DEVELOPMENT HEARING OFFICER

[PR-2019-002411](#)

SD-224-00126 – FINAL PLAT

Planning Comments

Plat for Aspire Subdivision Unit 4

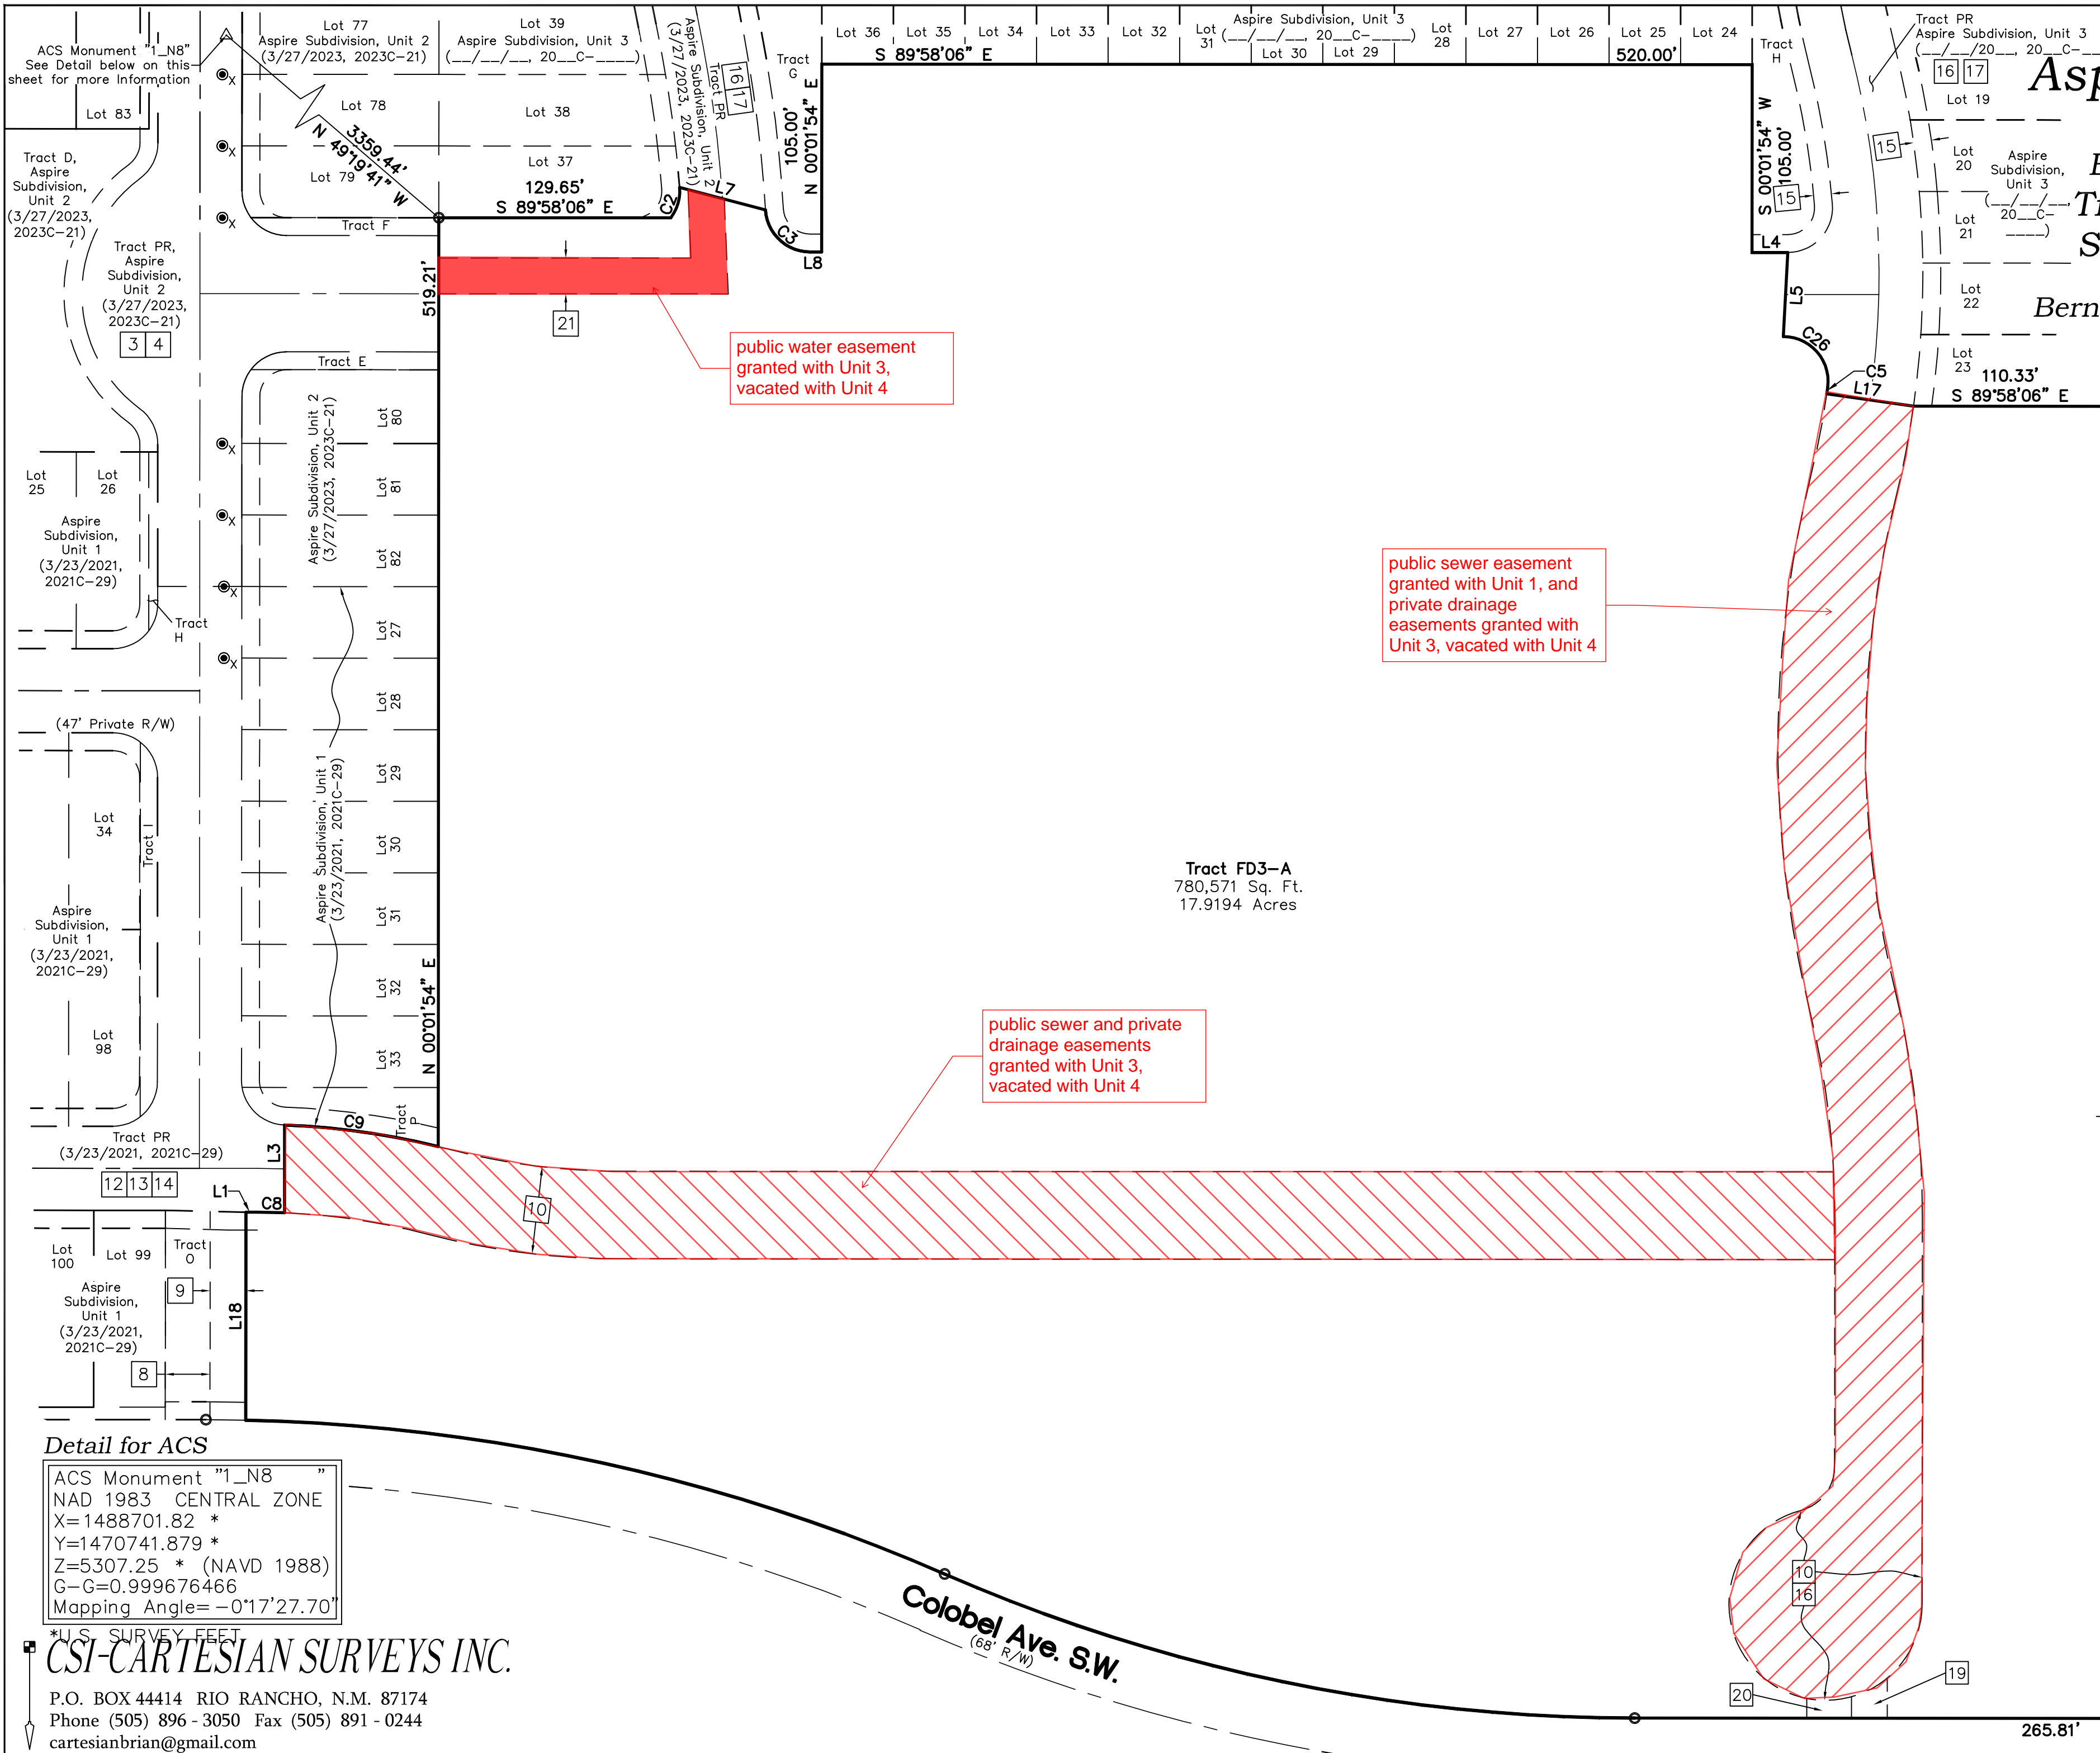
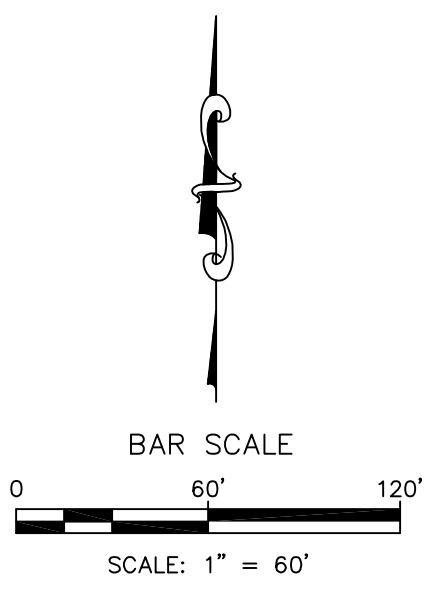
- These requests include the vacation of an existing public sanitary sewer and private drainage easement recorded on June 18th, 2024, the vacation of a 20-foot public waterline easement recorded on June 18th, 2024 the vacation of an existing public sanitary sewer easement recorded on March 23rd, 2021, and the vacation of a private drainage easement recorded on June 18th, 2024 (see Plat sheet above).

Please confirm if the vacation requests depicted on the Final Plat for Aspire Unit 4 match up with the labels/depictions for the future vacations on the amended Preliminary Plat for PR-2019-002411 / SD-2024-00088 as depicted below:

- Confirm that this request is not introducing any changes to the amended Preliminary Plat for PR-2019-002411 / SD-2024-00088.
- The Project and Application numbers must be added to the Plat.
- The date of the DHO approval shall be recorded on the Plat.
- After DHO approval and final sign off, a recorded copy of the plat must be sent to Jay Rodenbeck at jrodenbeck@cabq.gov and Angela Gomez at agomez@cabq.gov.
